MORGAN AND MORECAMBE OFFSHORE WIND FARMS: TRANSMISSION ASSETS

Annex 2.2 to Applicants' Response to Deadline 4 submissions from Statutory Consultees and other organisation: Fylde Borough Council (REP4-134)

Deadline: Deadline 5
Application Reference: EN020028

Document Reference: S_D5_2.2

**Figure 1.18: Hedgerows – Section 7a**

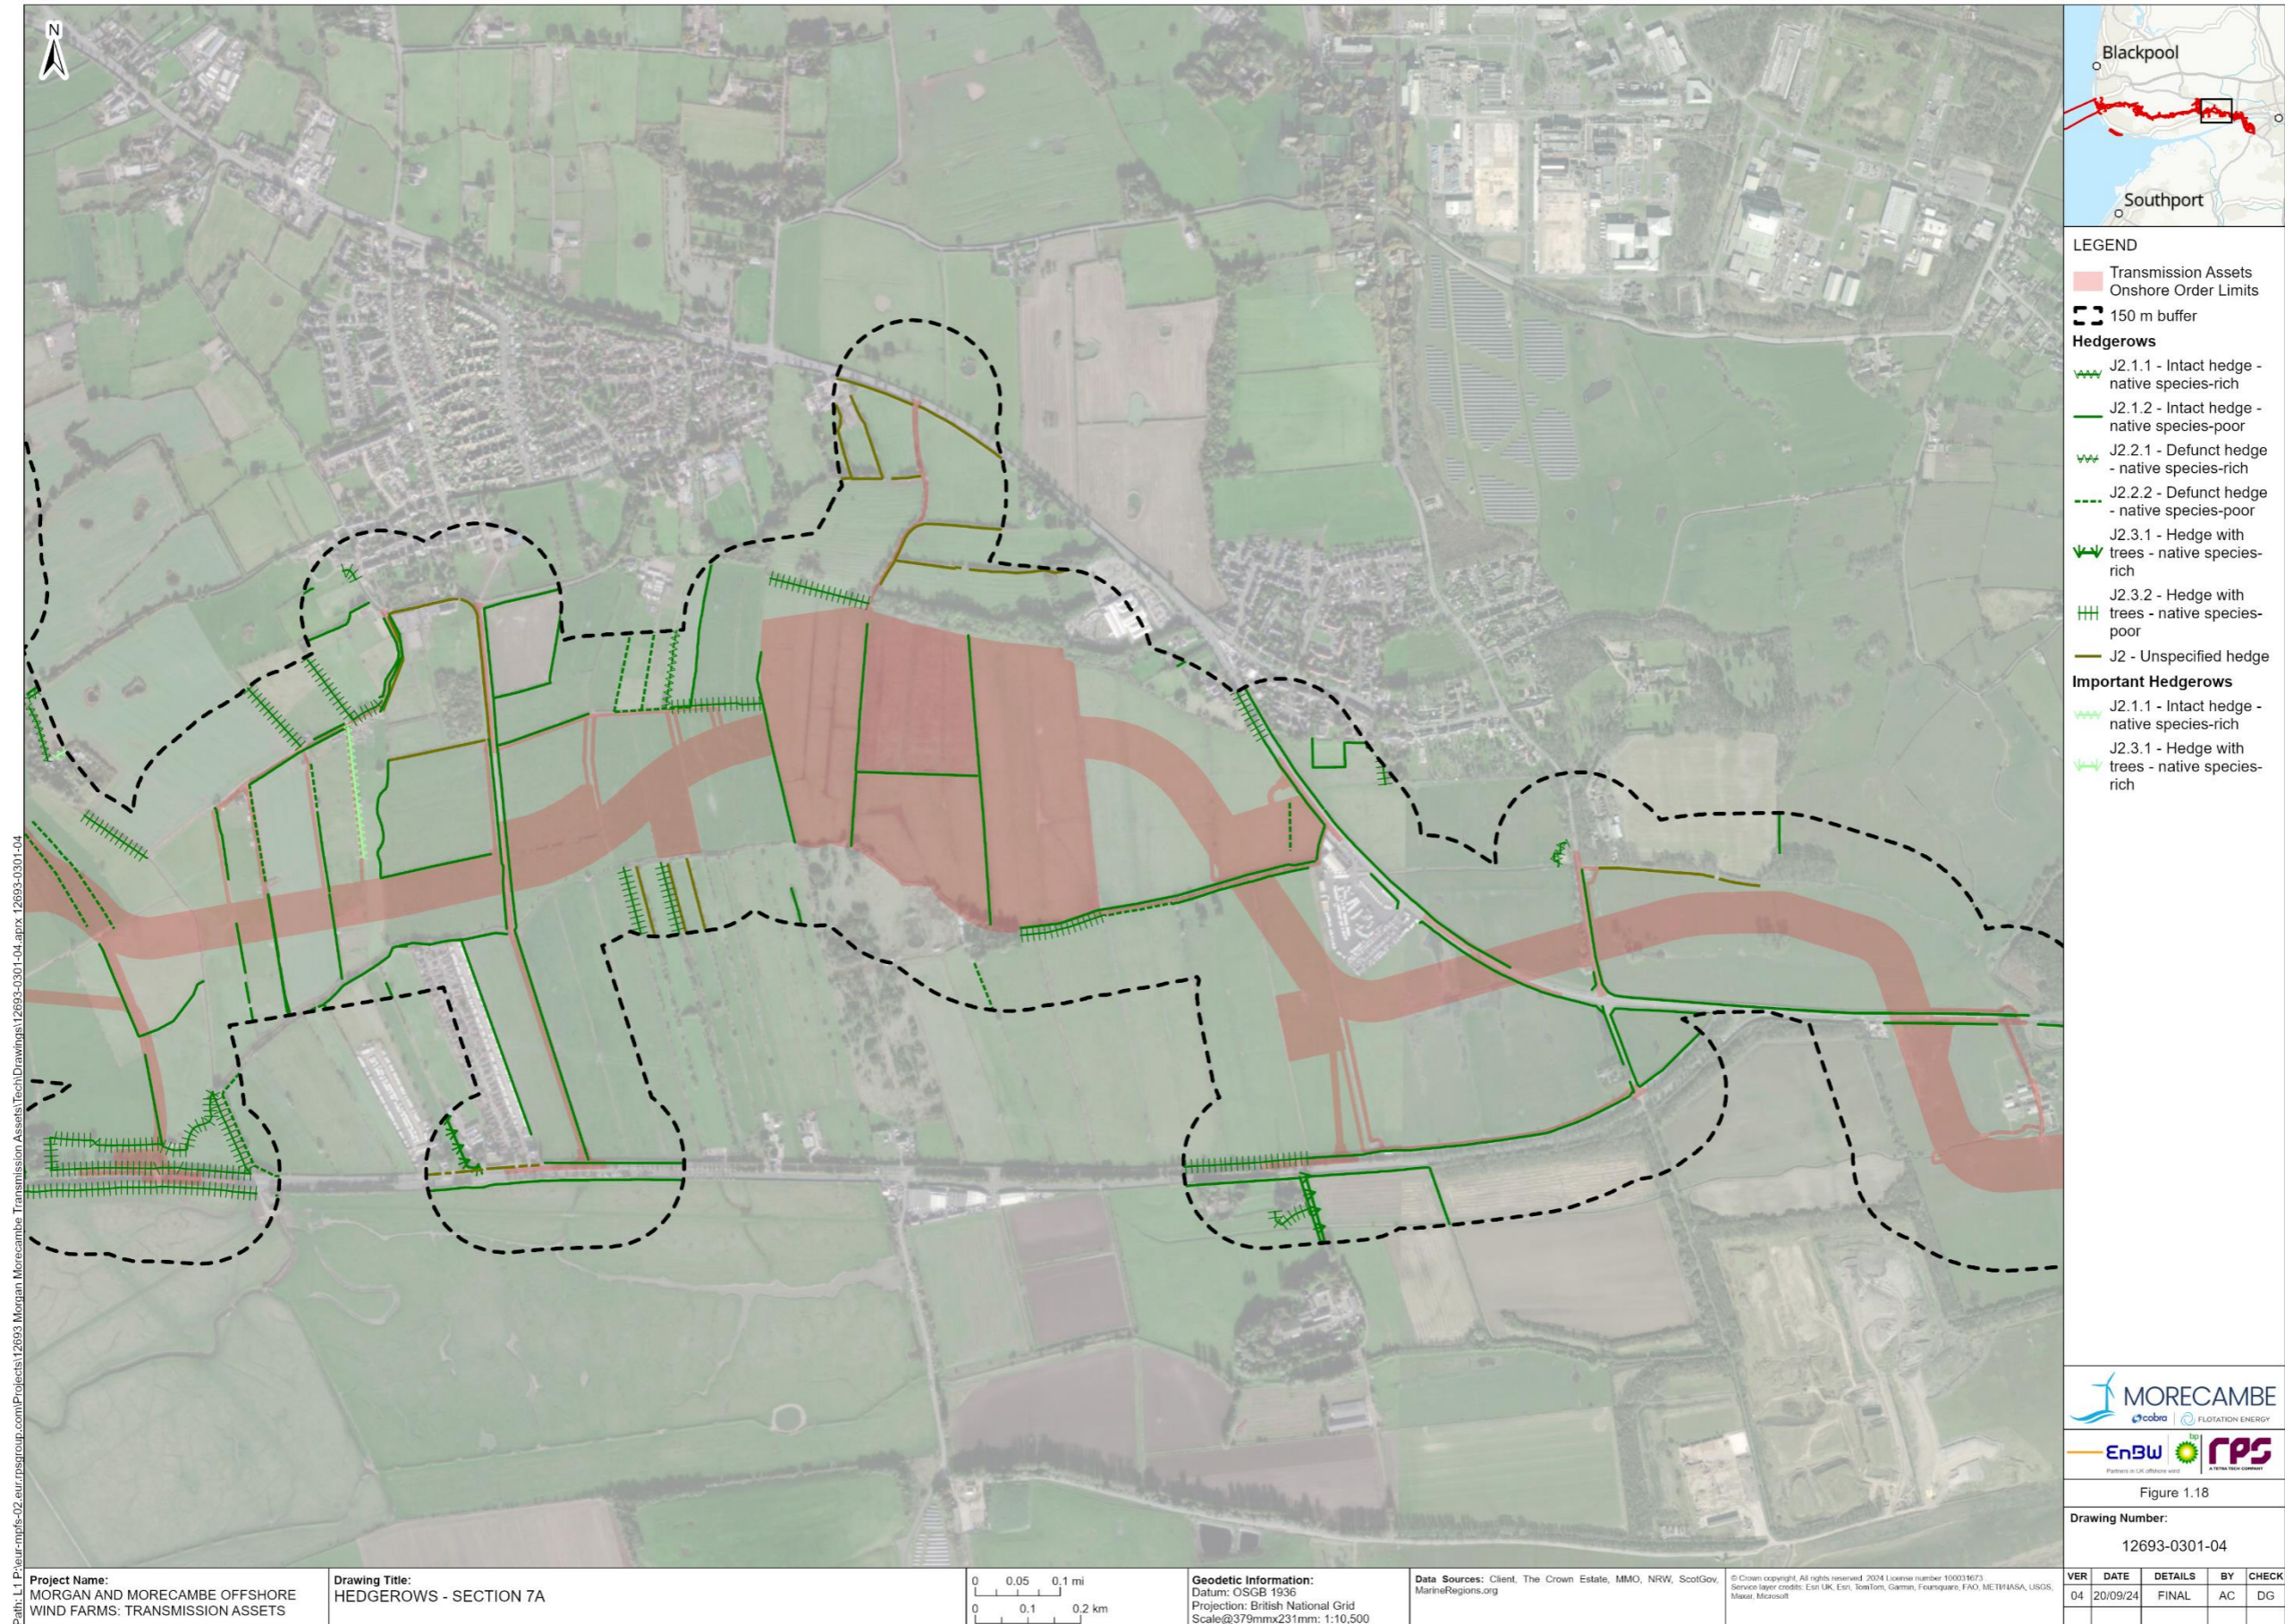
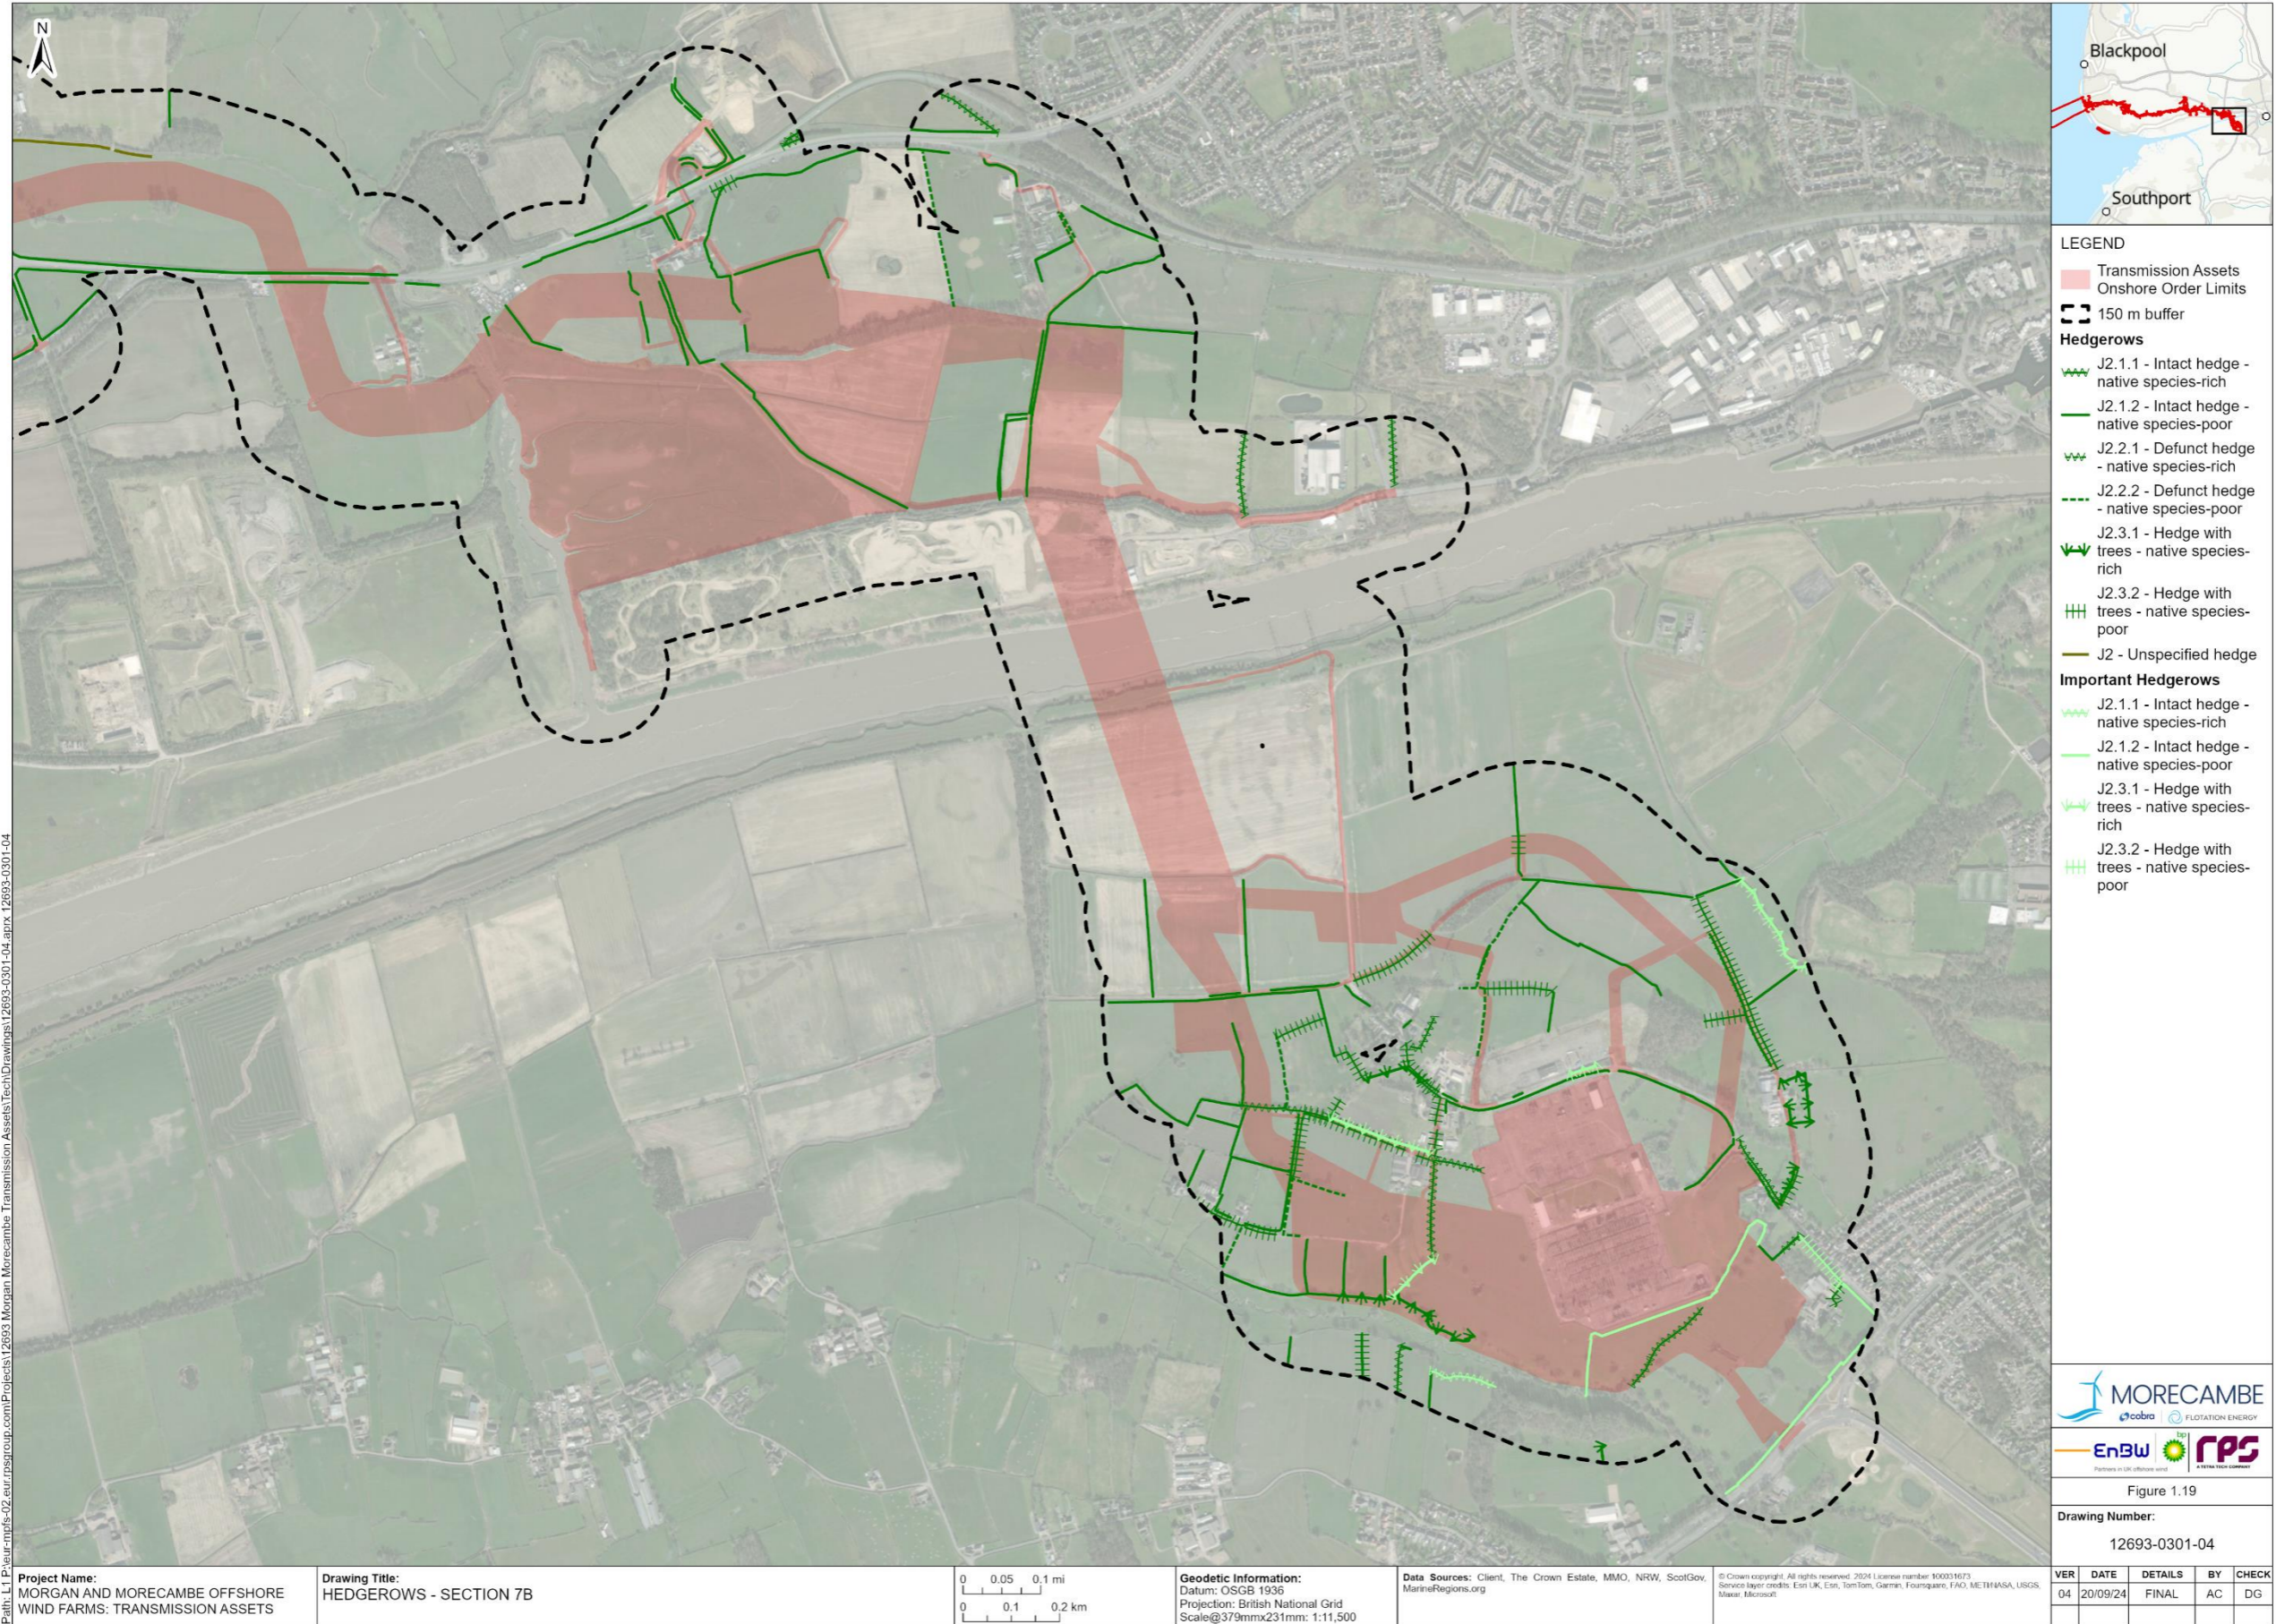
<p>REP4-134</p> <p>134.14</p>	<p>5.2 Scope of Hedge Removal</p> <p>5.2.2 The amount of hedgerow to be removed, as identified in Schedules 11A and 11B of the dDCO [REP3-009] is very large, at approximately 25km total. This is due to the large extent of the cable routing and Order limits significantly resulting in a greater and extended impact.</p> <p>5.2.3 Importantly, Section (4) of Article 35 of the dDCO allows for the removal of any hedgerow within the Order limits, in addition to those identified in Schedules 11A and 11B. FBC considers this to be unwarranted, inappropriate and not in accordance with Good Practice Point 6 of 'Advice Note Fifteen: drafting Development Consent Orders'</p>	<p>The Applicants have reviewed the wording of Article 35 against the Mona Offshore Wind Farm Order 2025 and consider that it is appropriate to update the drafting such that, unless otherwise agreed, Morgan can only remove important hedgerows that are identified in Schedule 11A and Morecambe can only remove important hedgerows that are identified in Schedule 11B. This is qualified by the inclusion of 'unless otherwise agreed', in light of the fact the Applicants have not been provided with full land access across the entire onshore Order limits and therefore it is possible that additional hedgerows may be identified when access to those areas of land is taken post consent. In the case of refusal,</p>

Reference	IP submission	Applicants' response
	<p>which requires all hedgerows affected by the proposed development to be identified within the Schedules.</p> <p>5.2.4 FBC requires that the applicants prepare a Schedule and plan in accordance with Good Practice Point 6 and that Article 36 of the DCO be updated to engage appropriately with these matters.</p>	<p>Morgan/Morecambe would be required to obtain a separate consent for removal of that important hedgerow.</p>
<p>REP4-134 134.15</p>	<p>5.3 Standards for Works to All Trees and Hedges</p> <p>5.3.2 Article 35 of the dDCO [REP3-009] allows for works to trees and hedges, including felling and removal, without any appropriate control.</p> <p>5.3.3 Neither the dDCO, nor the Commitments Register [REP3-013] make reference to any controls or standards in terms of how works under Article 35 would be carried out. A specification of works is therefore required.</p> <p>5.3.4 Section 5.11.27 of EN-1 includes a requirement for existing trees to be retained wherever possible and compensation provided where loss is unavoidable. It is entirely reasonable to extend this principle to require that works to retained trees to be carried out in such a way that harm to the long-term health of those trees is minimised.</p> <p>5.3.5 FBC therefore considers it appropriate to include control either within the DCO or Commitment Register, such as that works should be carried out in accordance with BS3998:2010 and BS5837:2012, and that tree health checks should be conducted by a suitably qualified Arboricultural Clerk of Works to satisfy the monitoring and supervision requirements within BS5837:2012.</p> <p>5.3.6 FBC requires like for like replacement for hedge loss, to achieve this recording of the hedge removal, tree/shrub species and soil types needs to be fully recorded. This is consistent with EN-1, FBC Local Plan Policies ENV1 and ENV3, and 'Advice Note Fifteen: drafting Development Consent Orders'.</p>	<p>The Applicants have prepared an outline Arboricultural Method Statement (S_D5_10) which is secured through Requirement 8 of Schedules 2A and 2B to in the draft DCO (C1/F07). Measures include but are not limited to:</p> <ul style="list-style-type: none"> Any further surveys required would be undertaken in accordance with BS5837:2012 All works to trees shall be carried out in accordance with BS3998:2010 and latest arboricultural best practice. All tree work shall be carried out by suitably qualified, competent and insured arboricultural contractors in accordance with Arboricultural Association Standard Conditions of Contract and Specifications for Tree Works (2008) Edition Measures to ensure tree health is considered and maintained throughout construction (such as construction exclusion zones and tree protection fencing) <p>The Applicants have also updated Section 1.6.3 of the Outline Ecological Management Plan at Deadline 5 (REF) to provide further clarity of the measures that would be in place to ensure the removal of and works to hedgerows are minimised. The measures include but are not limited to:</p> <ul style="list-style-type: none"> All hedgerows and trees retained within, or on the boundary of, construction work areas will be appropriately protected from damage during the construction works. A theoretical root protection area (RPA) is to be calculated, to ensure hedgerows and associated trees are not harmed by development activities

Reference	IP submission	Applicants' response
		<ul style="list-style-type: none"> Ensuring that all hedgerow removal works will comply with 'BS 5937:2012 Trees in relation to design, demolition and construction – Recommendations' Where hedgerow removal is proposed, works will be undertaken under ecological supervision. <p>In addition, paragraph 1.4.2.3 of the Outline Landscape Management Plan (REF) states that one of the main objectives of the landscape proposals is to reinstate land and plant replacement trees, hedgerows and other vegetation where practicable.</p>
REP4-134 134.16	<p>6 Ecology (Excluding dunes)</p> <p>6.1.2 FBC has provided separate comments relating to the sand dunes area within this written response.</p> <p>6.1.3 FBC notes the Action Points arising from ISH2 and ISH3 as they relate to ecology and will review the new and updated information as it becomes available. FBC expects to provide further written submissions, particularly in response to the range of Outline Management Plans relevant to ecological matters.</p> <p>6.1.4 FBC will also continue to engage with the applicants on matters relating to ecology. FBC can confirm that a series of meetings have been schedule ahead of Deadline 5 which should allow a substantively complete Statement of Common Ground [SoCG] to be submitted at Deadline 5, insofar as it relates to ecology.</p> <p>6.1.5 However, FBC also notes ongoing engagement between the applicants and key ecological consultees, notably Natural England and the Environment Agency. FBC notes with some concern the range of outstanding issues, including in relation to matters which have been a point of either disagreement or slow progress since at least 2023.</p> <p>6.1.6 The remainder of this section provides a summary of oral submission made by FBC at ISH2 and ISH3 as they relate to ecology.</p>	<p>The Applicants can confirm an SoCG meeting was held with Fylde on 5th September.</p> <p>The Applicants can confirm that there is ongoing engagement with EA and NE to discuss these matters. We consider this level of engagement to be typical of a project of this type and size and not anything of concern. Progress has been made on these issues and we do not consider this to be slow.</p>
